Planning Application Ref: 2026/92421
Location: 5 Far Bank, Shelley, Huddersfield, HD8 8LA

I wish to formally object to planning application 2026/92421 for the demolition of the existing bungalow and construction of a replacement dwelling at 5 Far Bank.

number 26022D -02 -P05

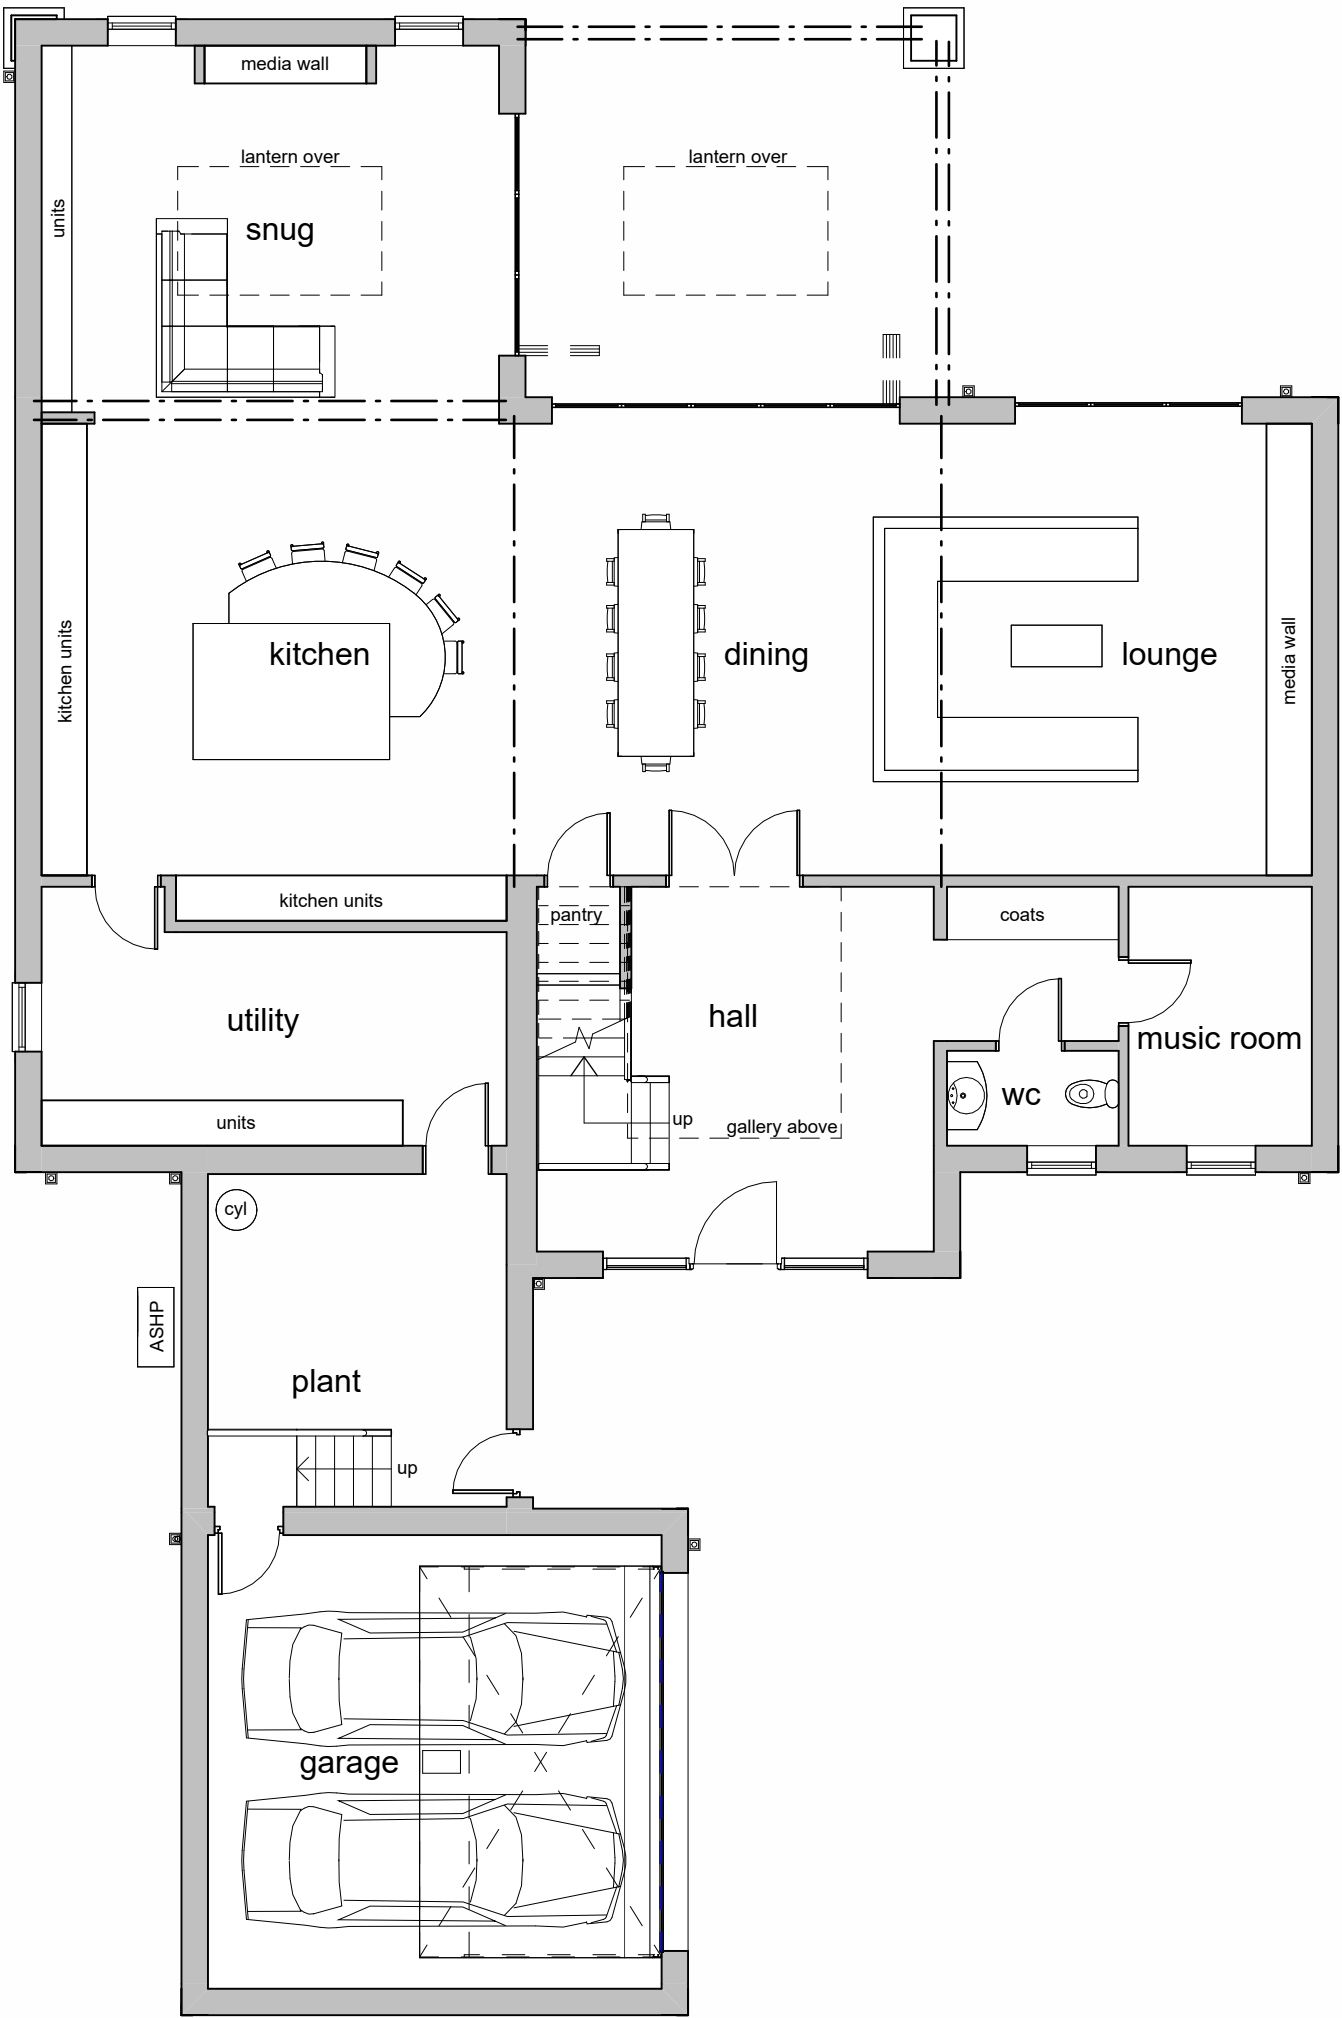
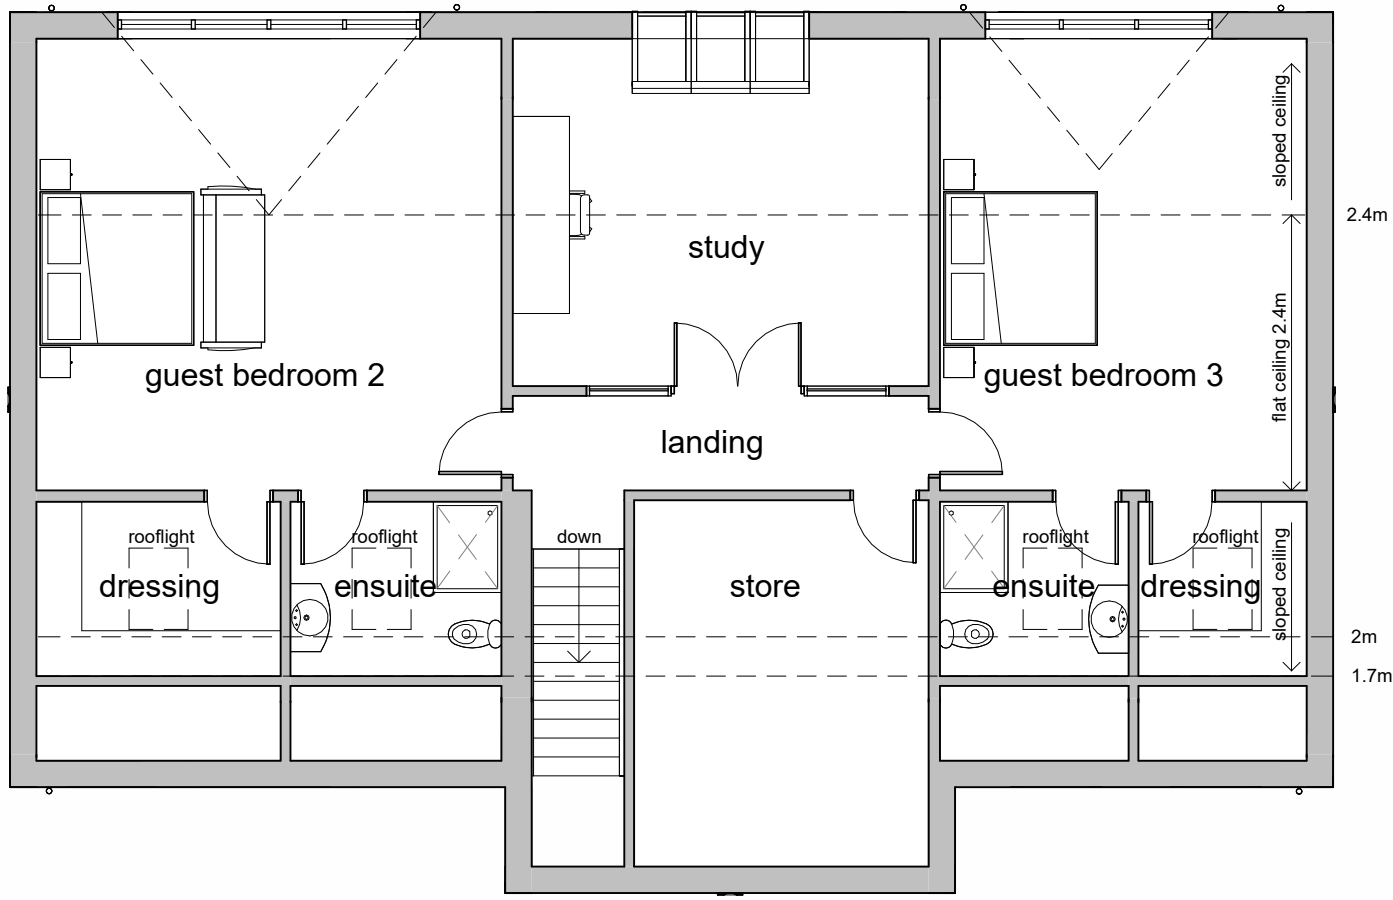
The proposed dwelling is substantially larger than the existing property and represents a clear overdevelopment of the site. Its height, massing and footprint are excessive for this prominent hillside location and out of proportion with neighbouring dwellings. The development would occupy a significant proportion of the plot and introduce a visually dominant structure that is wholly at odds with the established character and scale of development along Far Bank.

Properties along this section of Far Bank follow the natural gradient of the hillside, with rooflines stepping in harmony with the topography. The proposed dwelling would disrupt this established form, appearing significantly taller and more prominent than surrounding properties. The result would be a building that dominates the street scene and detracts from the traditional character of this part of Shelley.

Furthermore, the contemporary design and extensive glazing are not reflective of the traditional stone-built architecture that characterises the surrounding area.

The proposal would adversely affect neighbouring properties through overlooking, loss of privacy, loss of natural light and an overbearing presence, particularly in relation to 7 Far Bank. The height, scale and siting of the proposed dwelling would materially reduce the residential amenity currently enjoyed by neighbouring occupiers.
